Please find below Council's submission on this application:

Vehicle Crossing, Driveway & Parking

SITE PLAN  
SCALE: 1:200

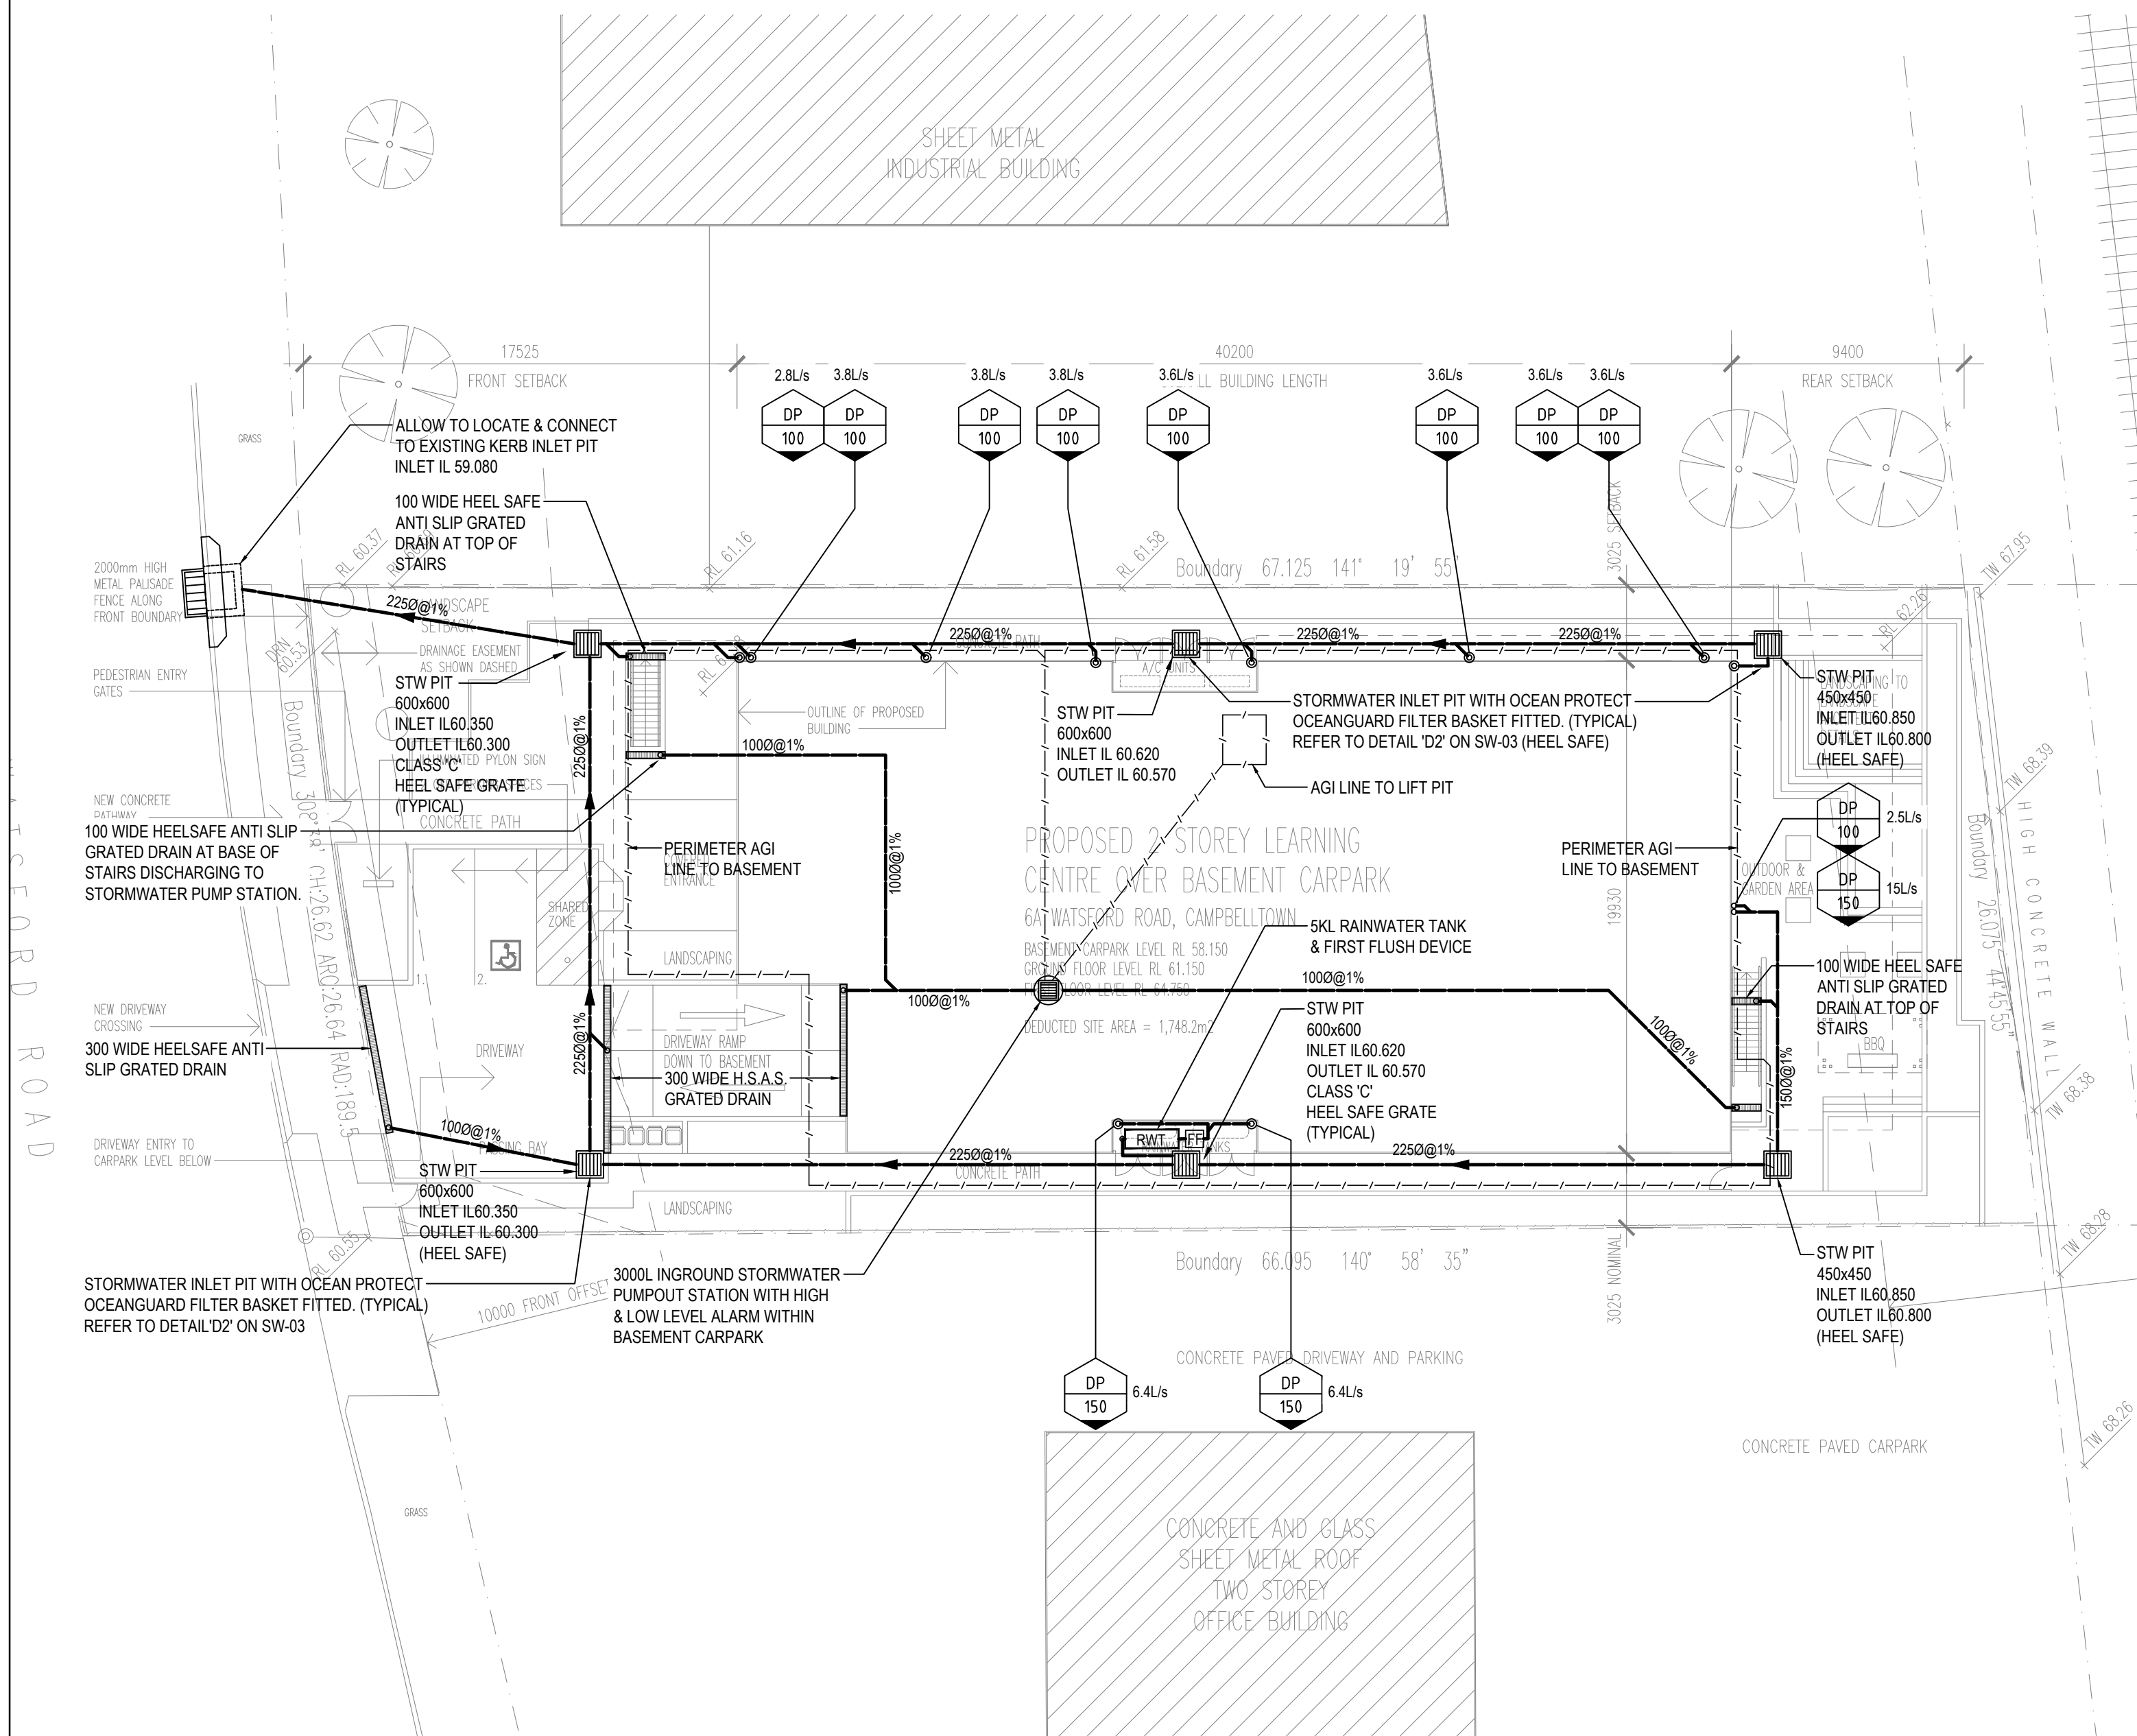
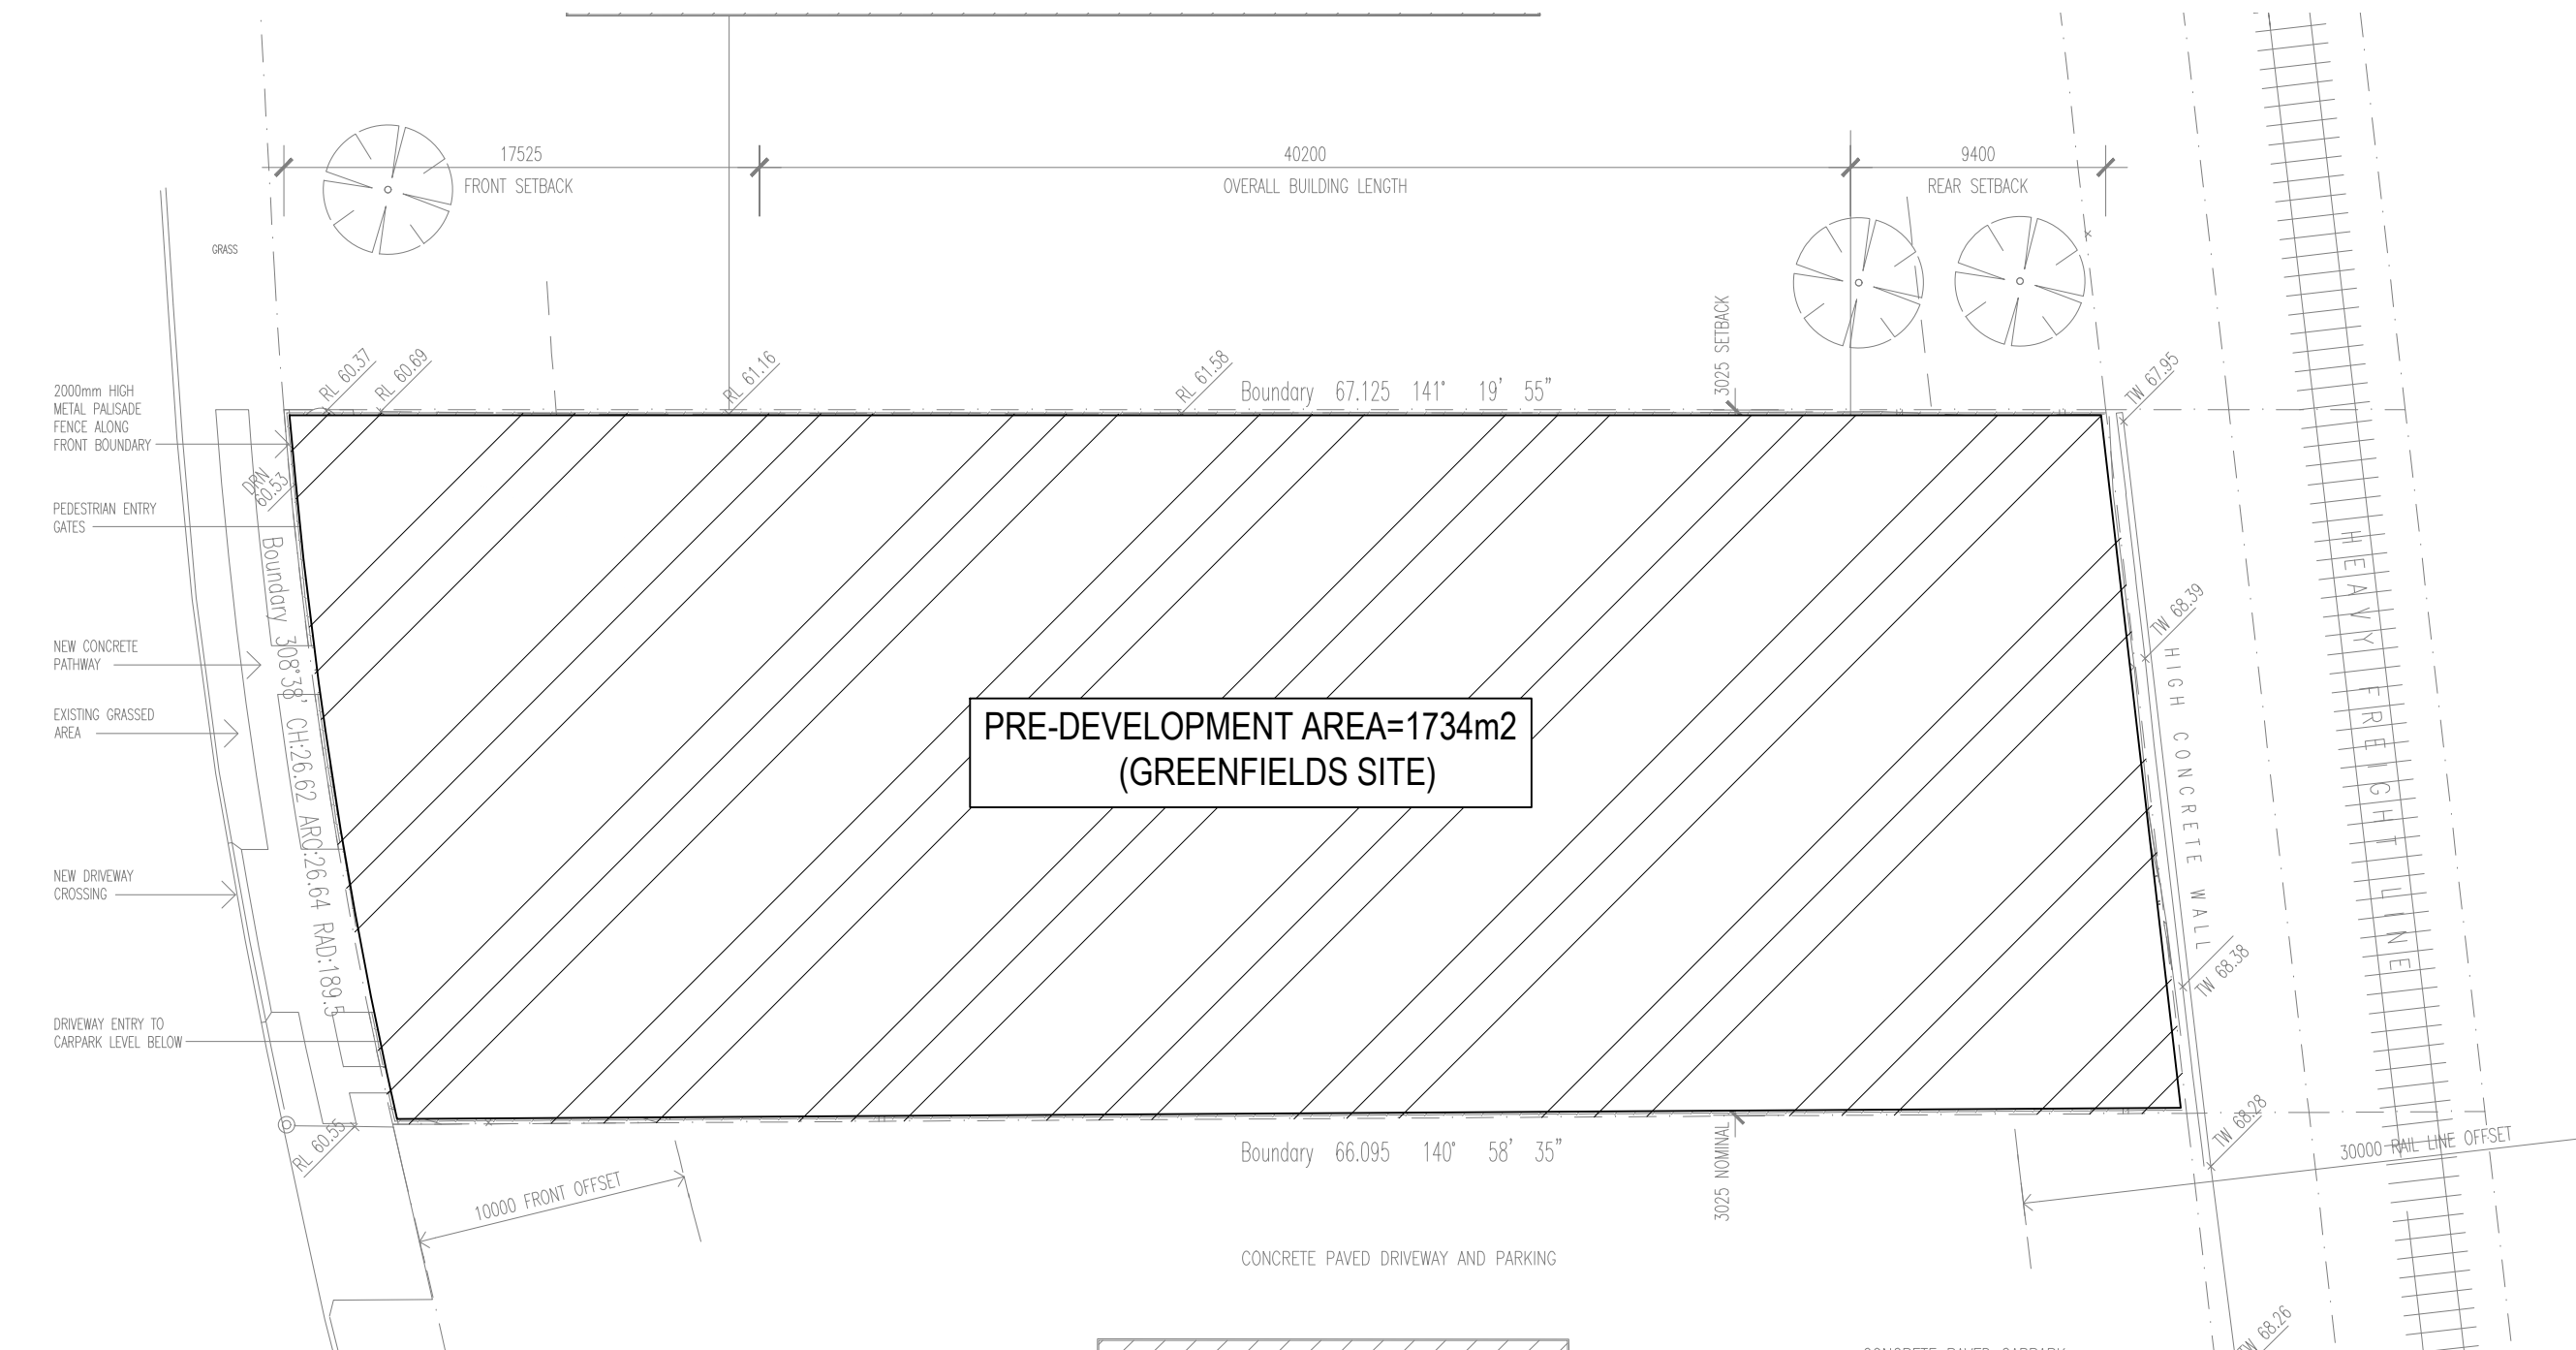
1. No stormwater calculations have been provided. Calculations shall be provided as per Council's Engineering design guide and may require redesign of the stormwater configuration.

2. Stormwater shall comply with Council's Engineering Design guide for developments.
3. The applicant shall demonstrate limiting post-development flow to pre-development flow, and this may require provision of an On-site detention system.

4. The pipeline in the road reserve shall be reinforced concrete minimum (375mm diameter class 3 minimum).
5. The proposed piped connection from the boundary to the existing kerb inlet pit will require adjustment / relocation of services (Sydney Water, Telecommunication, Electricity). This shall be undertaken at the applicant's cost and to the satisfaction of Council and relevant utility authority.

8. It is noted that there is a drainage easement adjacent at the front property boundary however it is unclear why. It may be related to the sub-division of the parent lot into lots 6 & 6A.
